**RE: SUB22-005 (Feng Preliminary Short Subdivision)
Request for Information #1
7204 78th Ave SE, Mercer Island, WA 98040**

We have outlined below our responses to your request for information on Short Plat Submittal with Number: SUB22-005. We refer to sheet numbers and noting to each item where the requested information can be found. Please let us know if you have further comments.

SURVEY

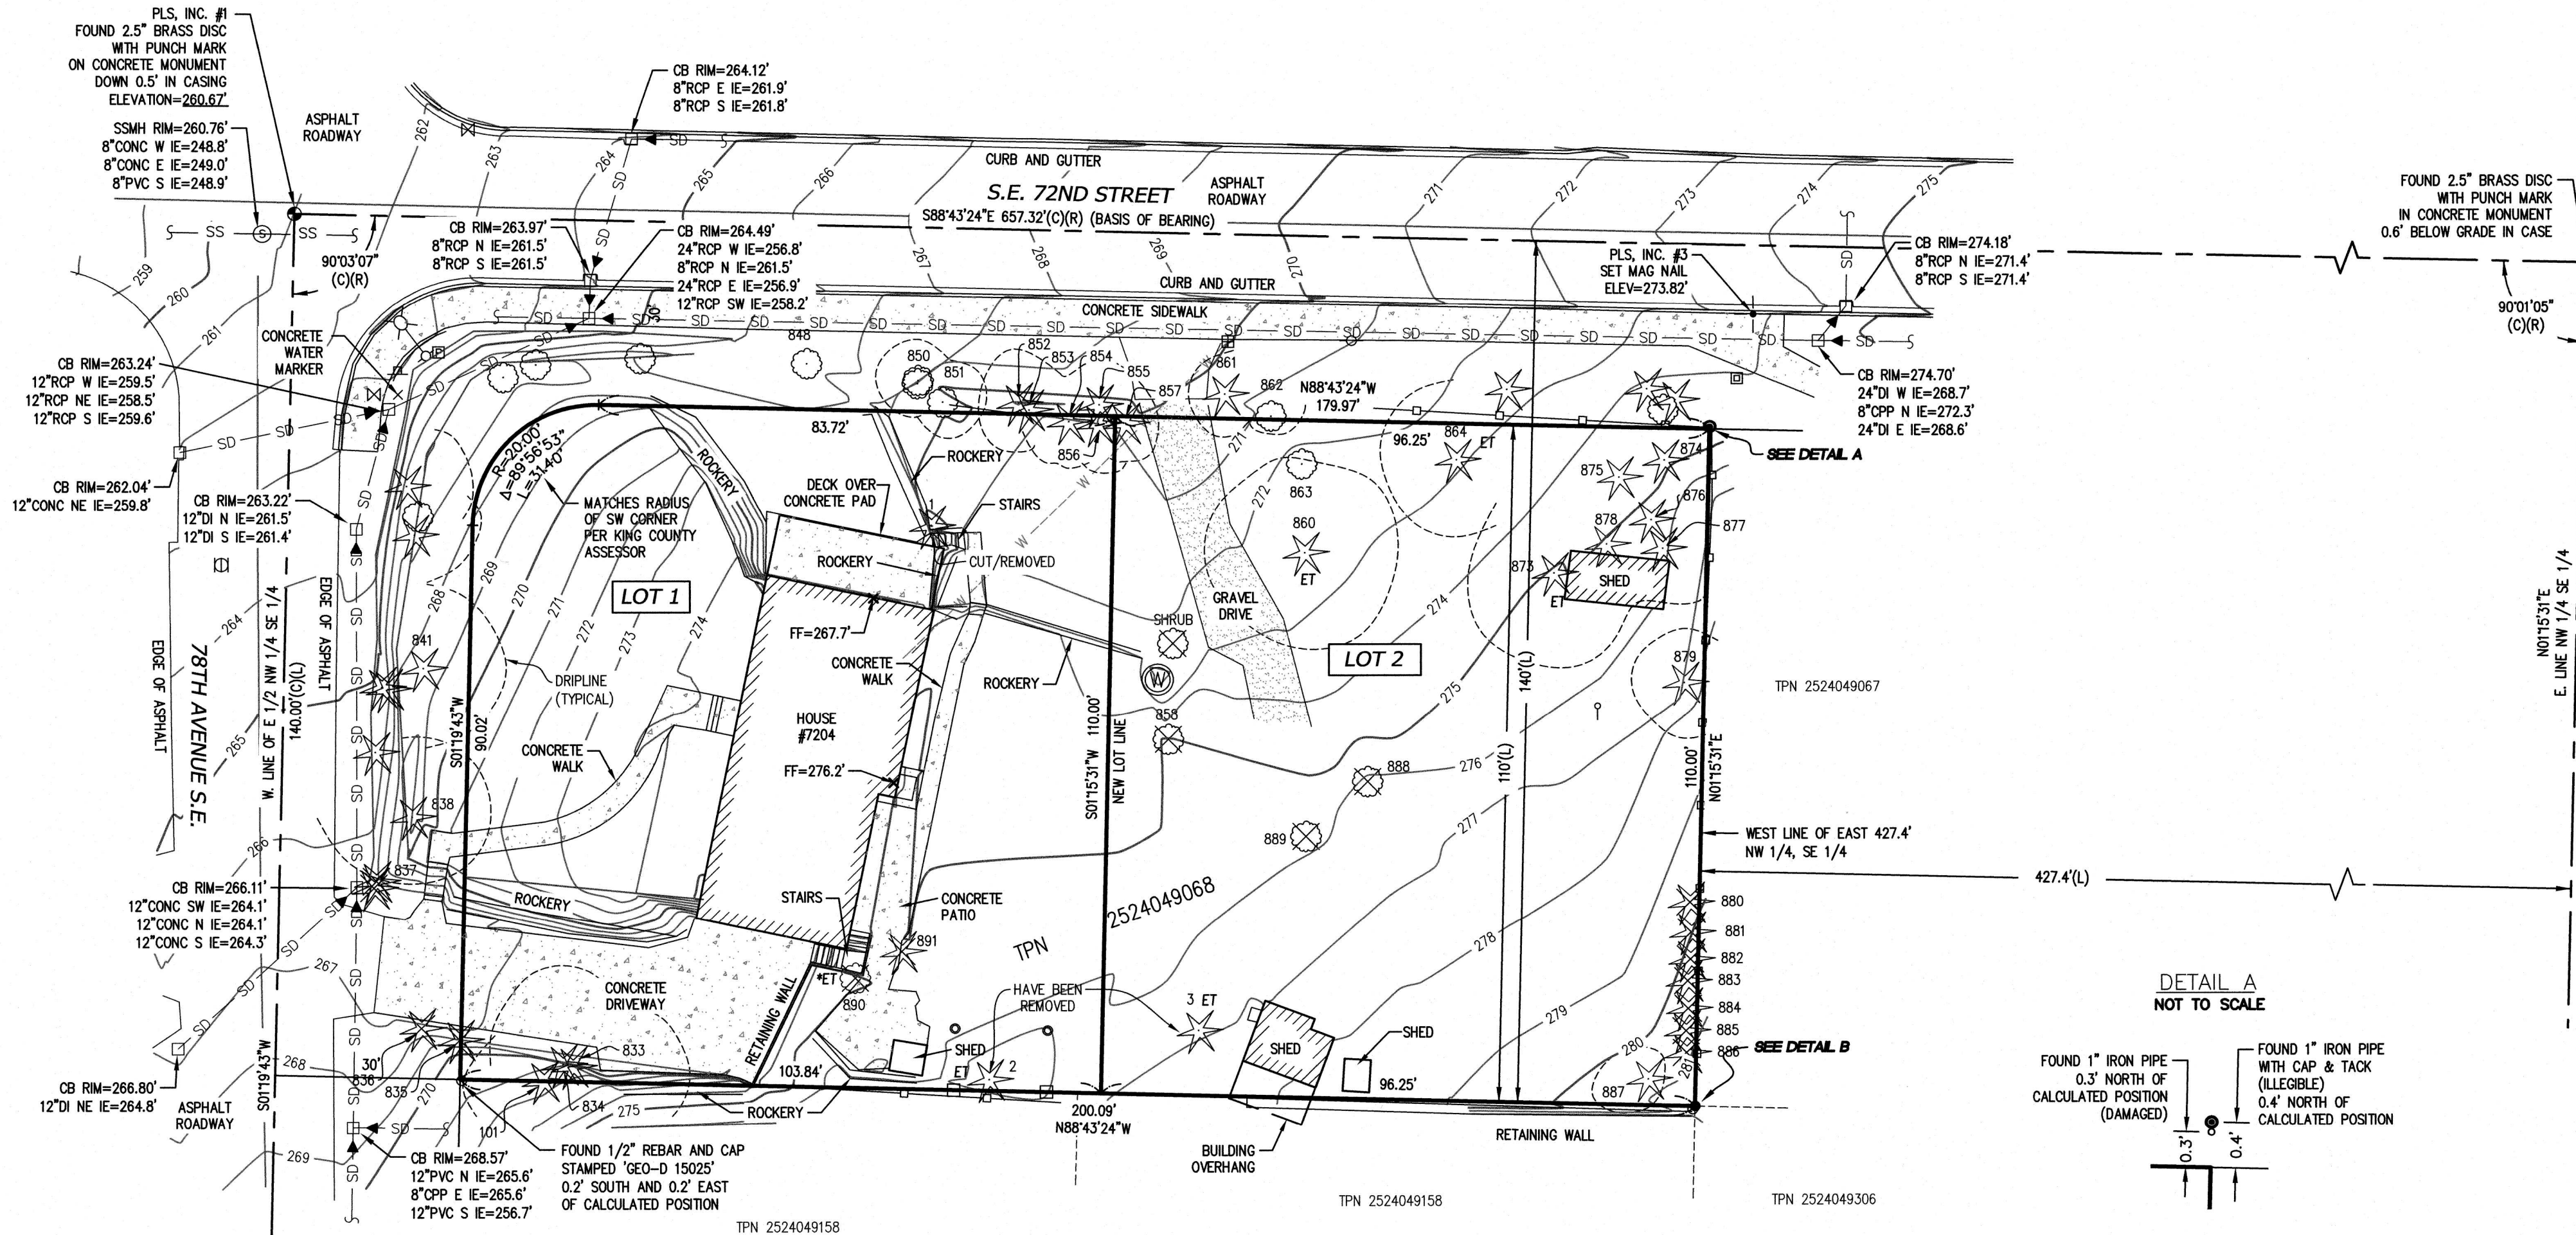
7. The plat drawing shall be prepared in conformance with Title 58 RCW and surveys shall comply with Chapter 332-130 WAC. Please submit using Mercer Island's datum and tie the plat to at least two monuments.

[Response: Requirements are incorporated in Survey Plan, sheet 3 of 9.](#)

SHORT PLAT

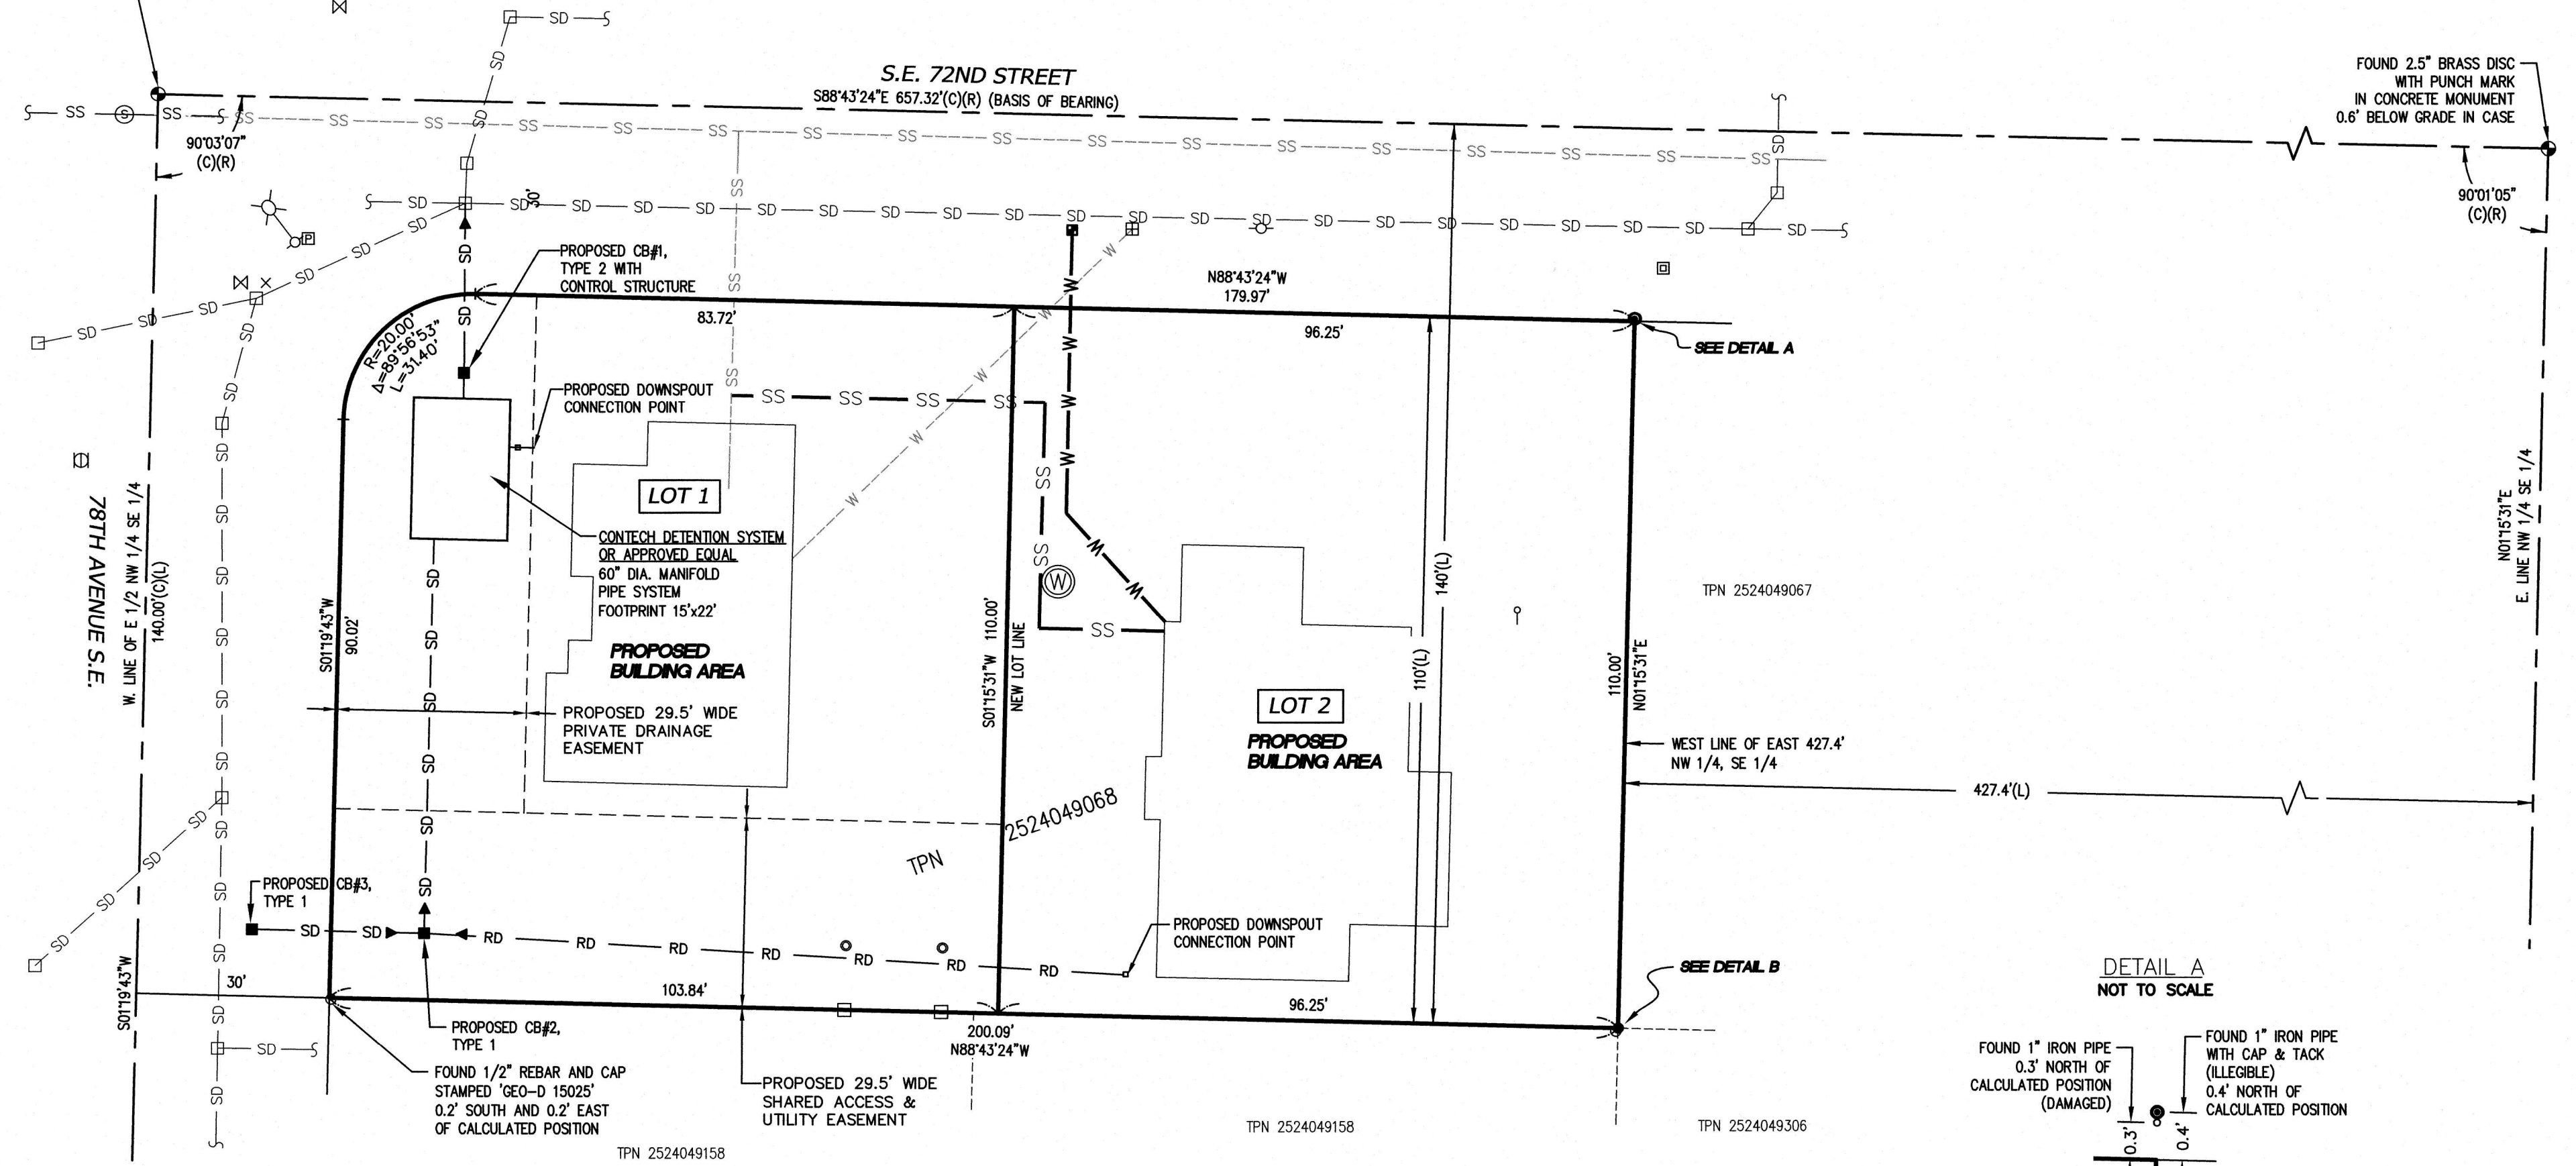
5. Please provide a plat drawing showing the lot lines with distances, bearings, and legal descriptions, and the existing and proposed easement limits with legal descriptions, dimensions, purposes, grantee, and grantor of the subject easements.

10. The shared detention system and storm drainage system shall be in a private drainage easement. Please show the private drainage easement on the plat drawing.

[Response: Plat map is provided on sheet 5 of 9. Requirements are incorporated.](#)

[Response: Private drainage easement is demarcated in Plat drawing, sheet 5 of 9.](#)

PRELIMINARY SITE PLAN

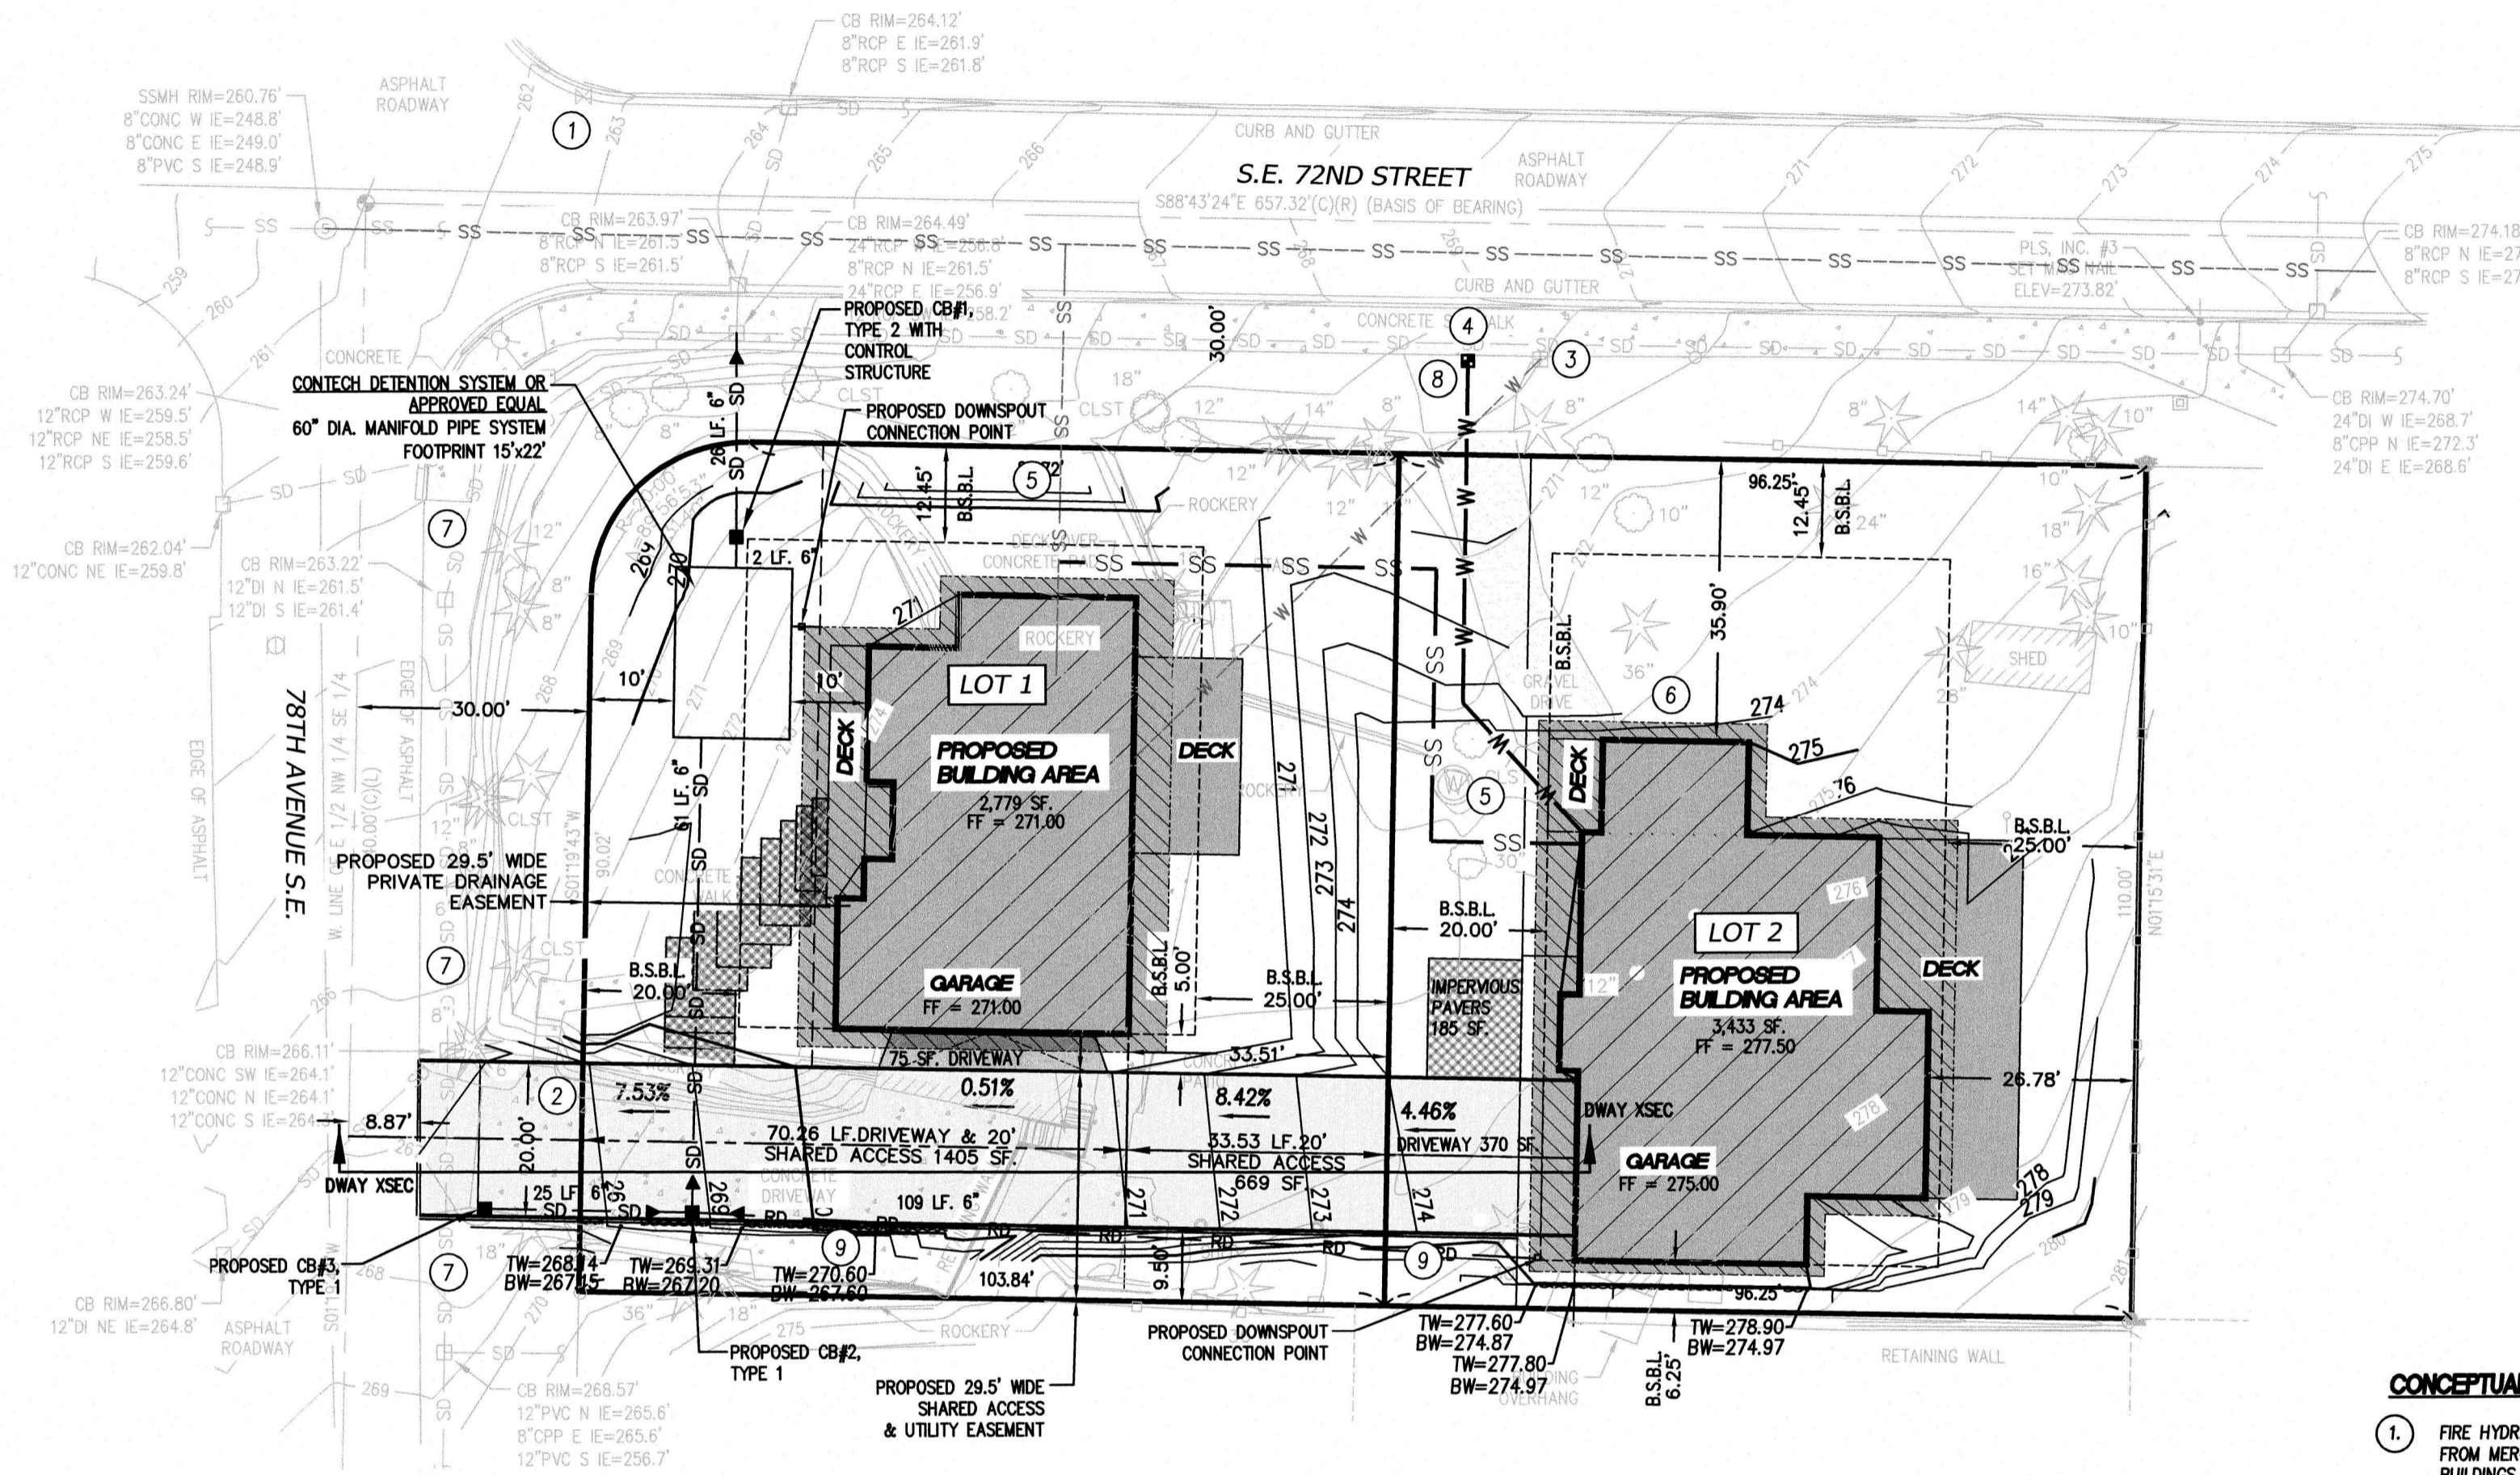
11. Please identify that the 20-foot access road from 78th Ave SE to the east lot is considered Emergency Vehicle Access and shall not be blocked.

[Response: Requirement included in the Conceptual Construction Notes on the Preliminary Site Plan, sheet 6 of 9.](#)
